Apt.27 Esplanade Grande,
The Esplanade,
Bognor Regis,
PO21 0AD,

Mr. R. Temple
Planning Officer,
Arun District Council.

Planning Application BR/194/17/PL.

North Elevation

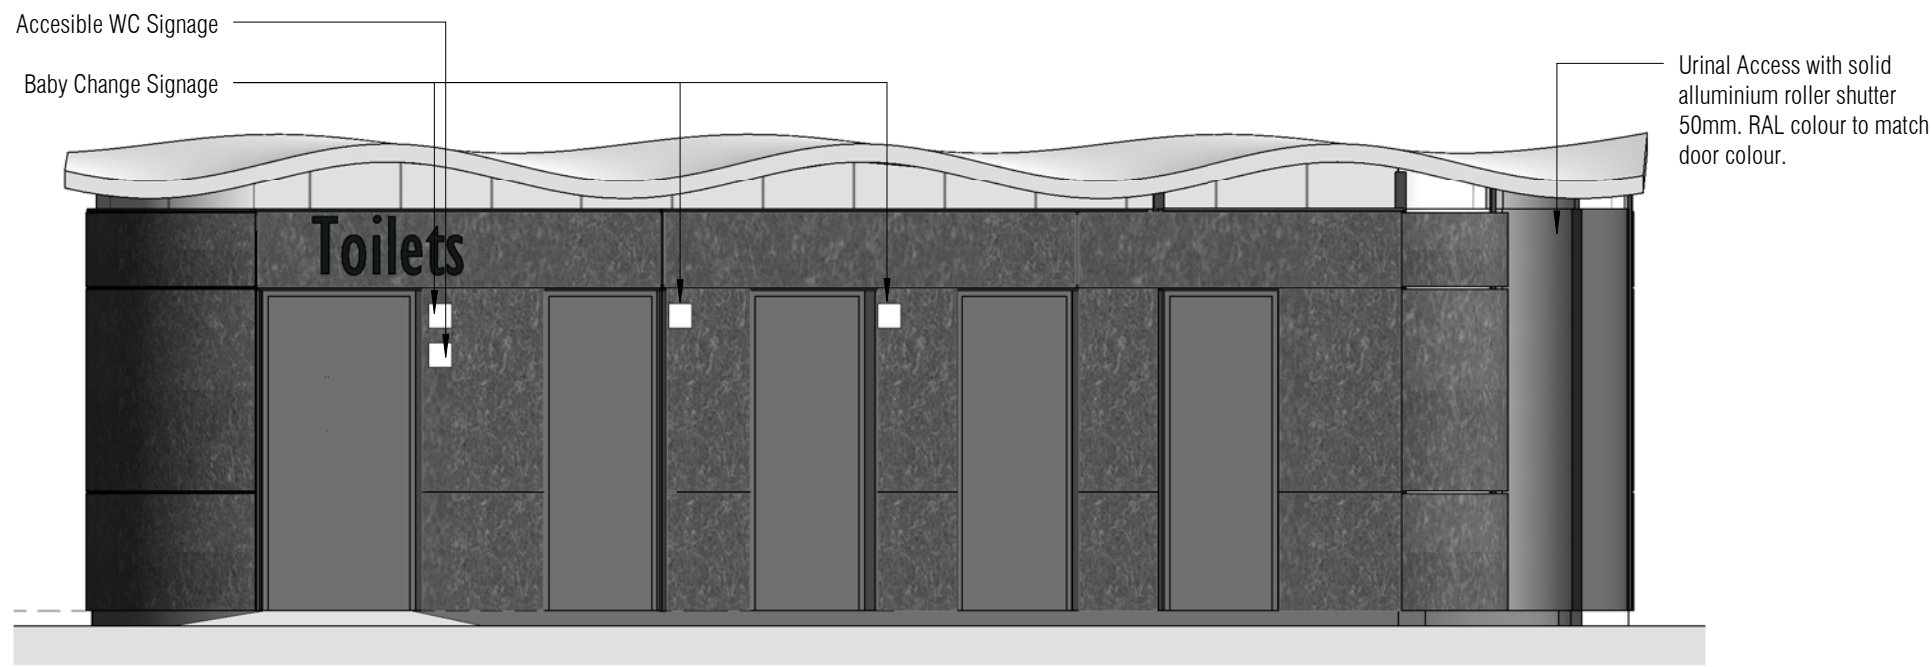
The plan of the outside toilets shows the doors facing north and this is offensive to the residents opposite. This means the sea view will change into a 24/7/365 days view of urinals, adjustment of clothing, banging of doors, doors left wide open. Children will be tempted to climb the metal railings, resulting in an accident. Access to an outside toilet should face south giving direct access from the beach. A better position for the proposed toilets should be opposite Clarence Road or opposite Butlins car park, without giving offence to residents.
